# CITY OF PORTLAND BUILDING PERMIT

**PERMIT ID:** 2012-65516

has permission to **To construct a 24 X 32 single family house - cape with full dormer - 16 Castine Avenue**

**From:** Jonathan Rioux  
**To:** Jim Wolf  
**Date:** 1/2/2013 9:01 AM  
**Subject:** 18 Castine Ave.

RIDGE VENT  
 PRE-MANUFACTURED ROOF TRUSSES @ 24" O.C.  
 ROOF SHINGLES  
 5/8" APA RATED SHEATHING W/ 8d NAILS, RING SHANK @ 6" O.C. INTERMEDIATE  
 #15 FELT PAPER  
 (2) ROLLS 36" WIDE WATERPROOF MEMBRANE @ EAVES.

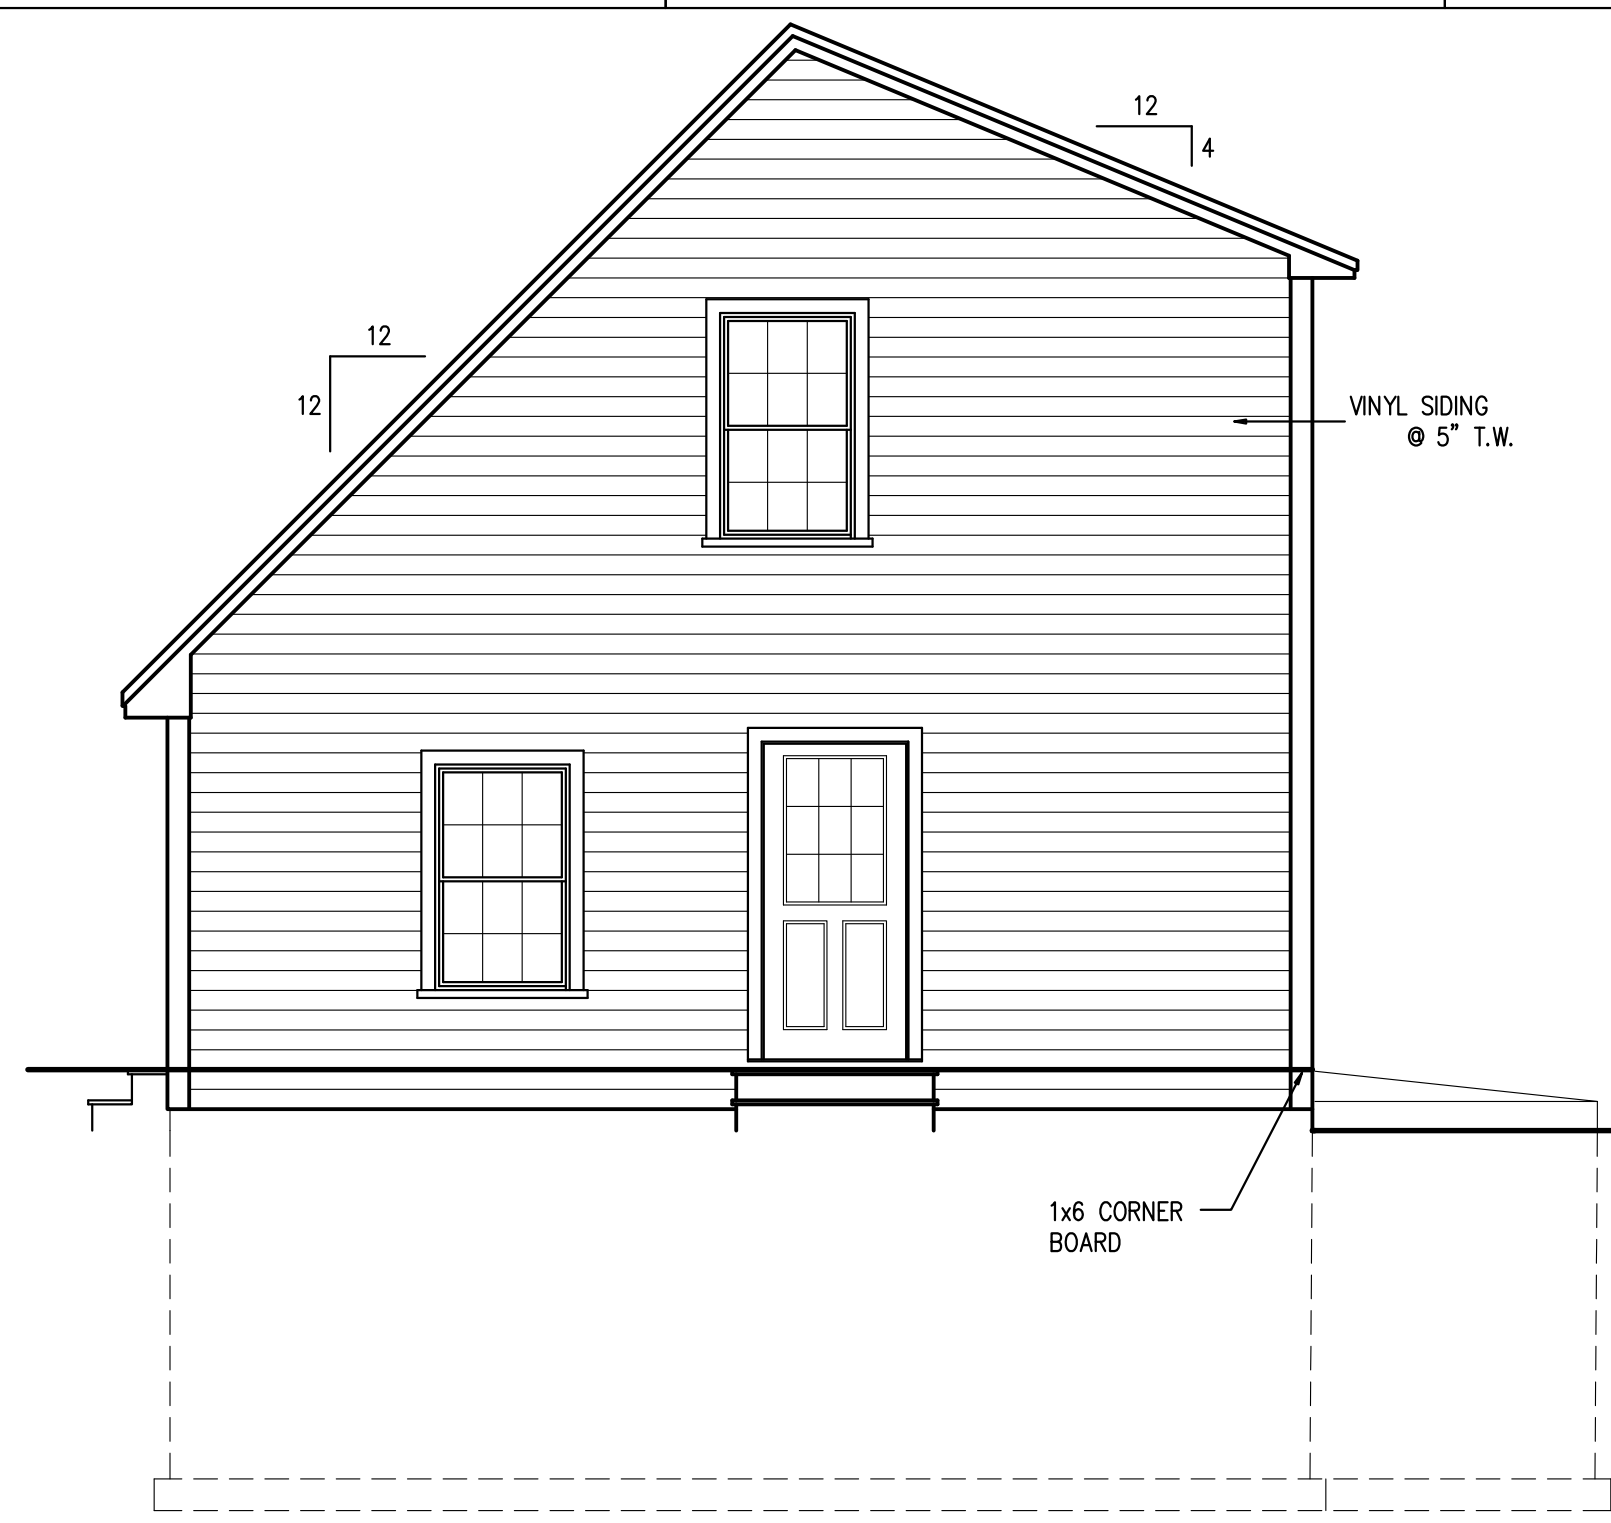
- A2 (our copy) does not show a cross section/ framing plan for a full or partial dormer.
- Is the residence going to have trusses or wood rafters?
- Is there attic access?
